Please ask for: Ms Iqraa Malik
Email: iqraa.malik@terraquest.co.uk
Telephone: 01212341390
Our Ref: AW/263/21/HH
Your Ref:
Date: 28th July 2021

Application for Planning Permission for Works or Extension to a Dwelling

Development: Erection of single storey rear infill extension, first floor rear extension, conversion of garage to habitable use, porch canopy to front with pitched roof and alterations to fenestration
Location: 4 St Richards Drive Aldwick PO21 3BH

Site Plan proposed
1 : 200

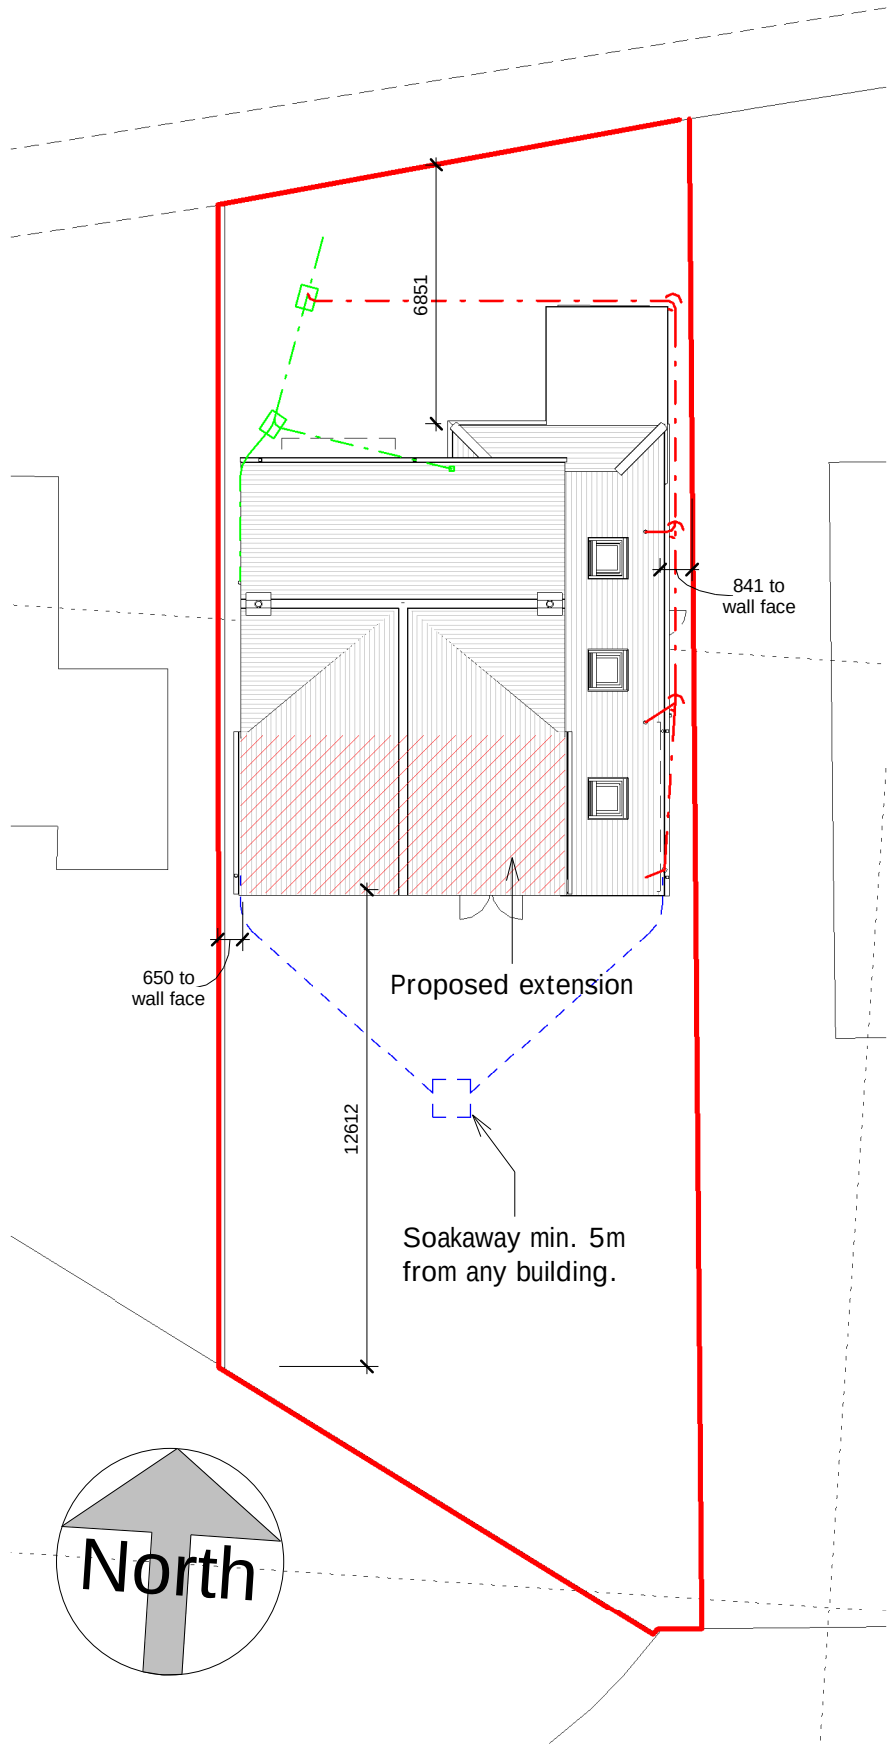
Dimensions: You are required to include dimensions on the block plan from the proposed extensions to all site boundaries. Please amend
